WEST SUSSEX COUNTY COUNCIL CONSULTATION

TO:	Arun District Council FAO: D. Easton
FROM:	Highways, WSCC
DATE:	23/05/2018
LOCATION:	Oldlands Farm, Steyning Way, Bognor Regis, PO22 9NN
SUBJECT:	AL/44/18/RES Application for all reserved matters following outline consent AL/58/15/OUT (Hybrid Application) for up to 20,453 sqm of B2 general industrial floorspace together with B8 warehousing & distribution floorspace (as amended by subsequent Variation of Conditions 11, 12 & 37).
DATE OF SITE VISIT:	N/A
RECOMMENDATION:	
S106 CONTRIBUTION TOTAL:	N/A

Proposed Site Layout with B2 and B8 use

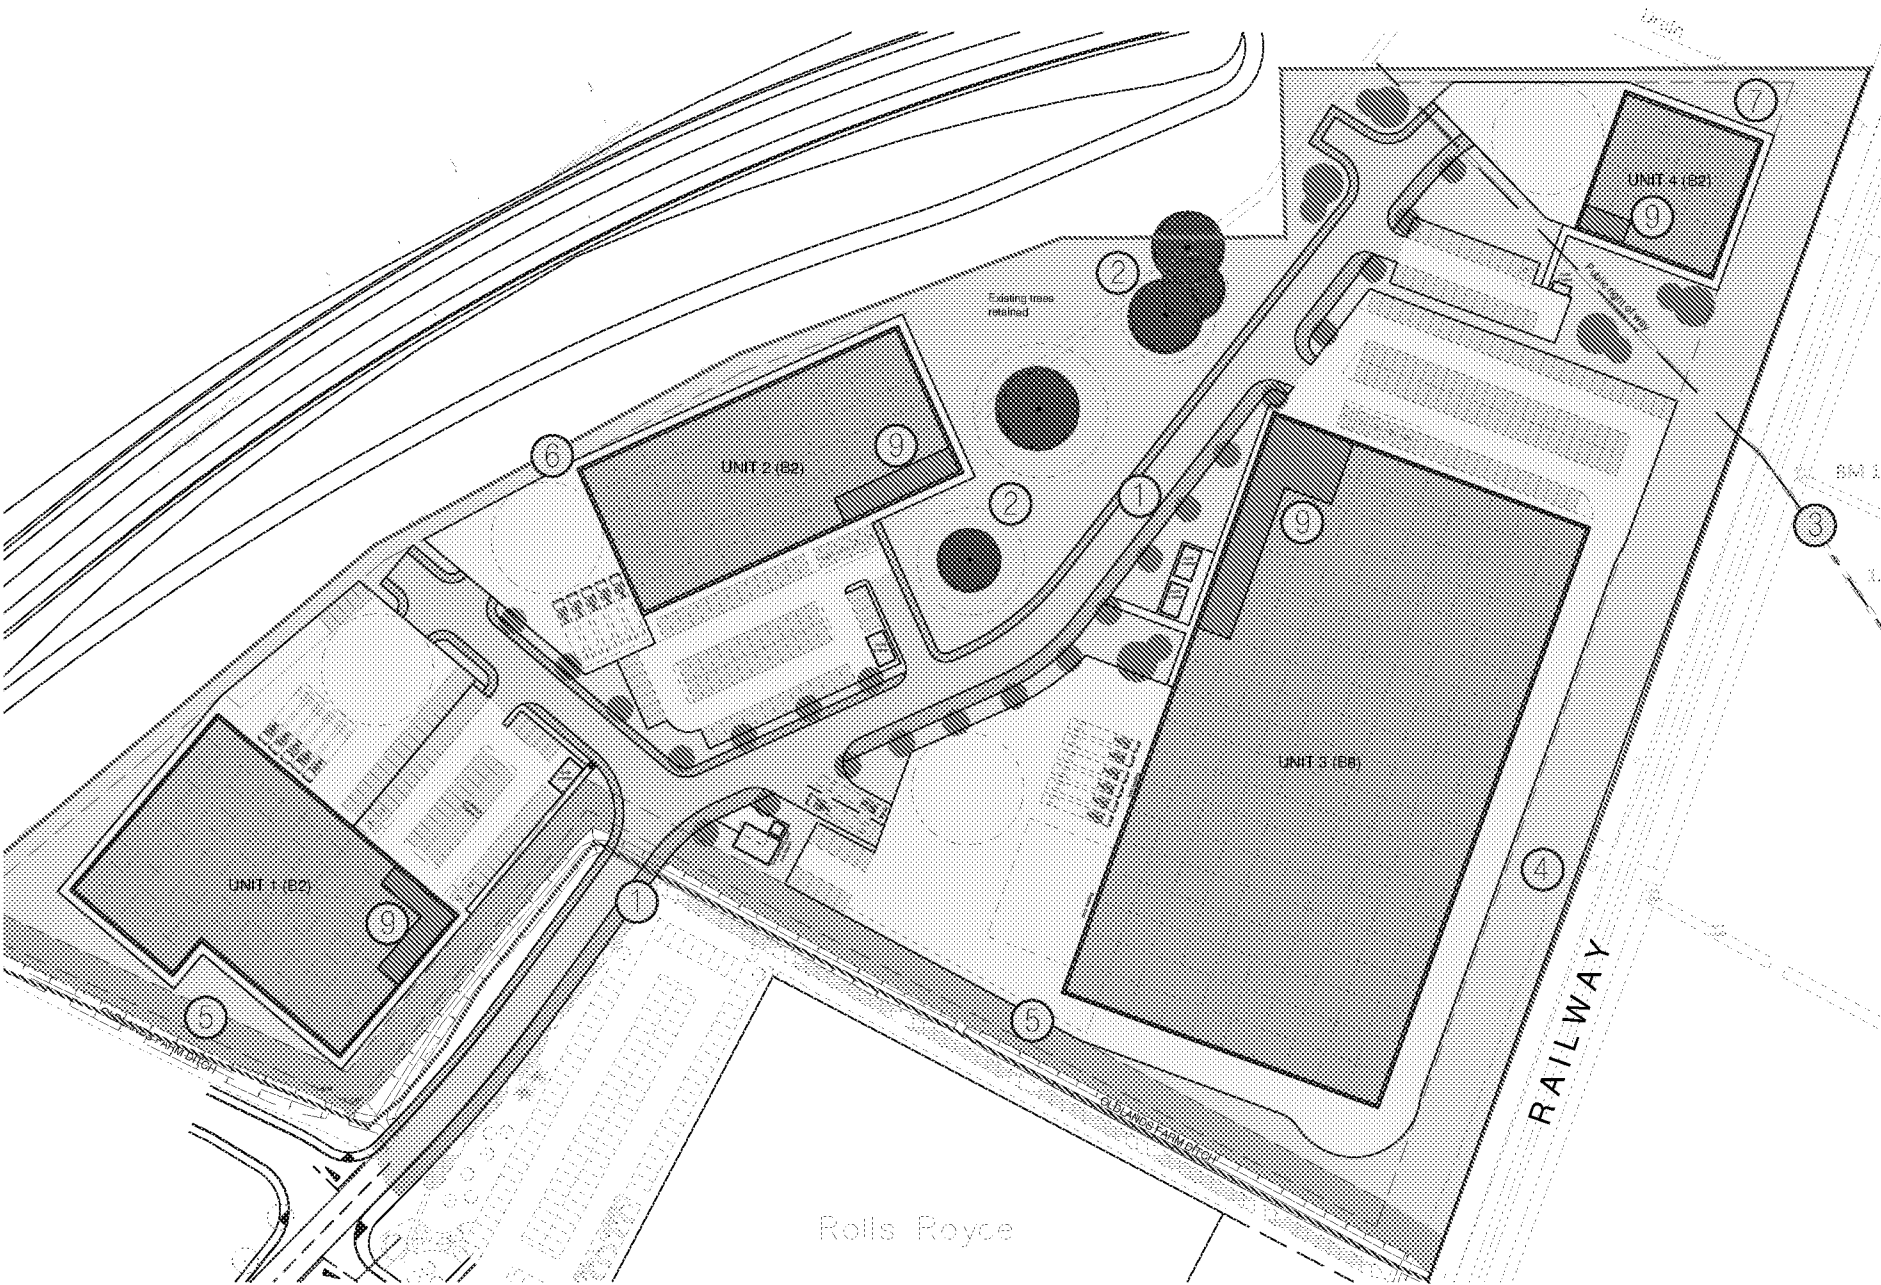
The internal access roads have been designed in accordance with Manual for Streets (MfS) parameters with 2 metre footways and tactile paving linking crossing points. Swept path diagrams have been provided for all aspects of the

'Phase 2' aspect of the development. This demonstrates that HGV traffic can negotiate each of the proposed parking compounds and details are accepted by the LHA. Appropriate visibility has been provided for all of the internal junctions. Specific parking allocations in accordance with WSCC parameters have not been provided.
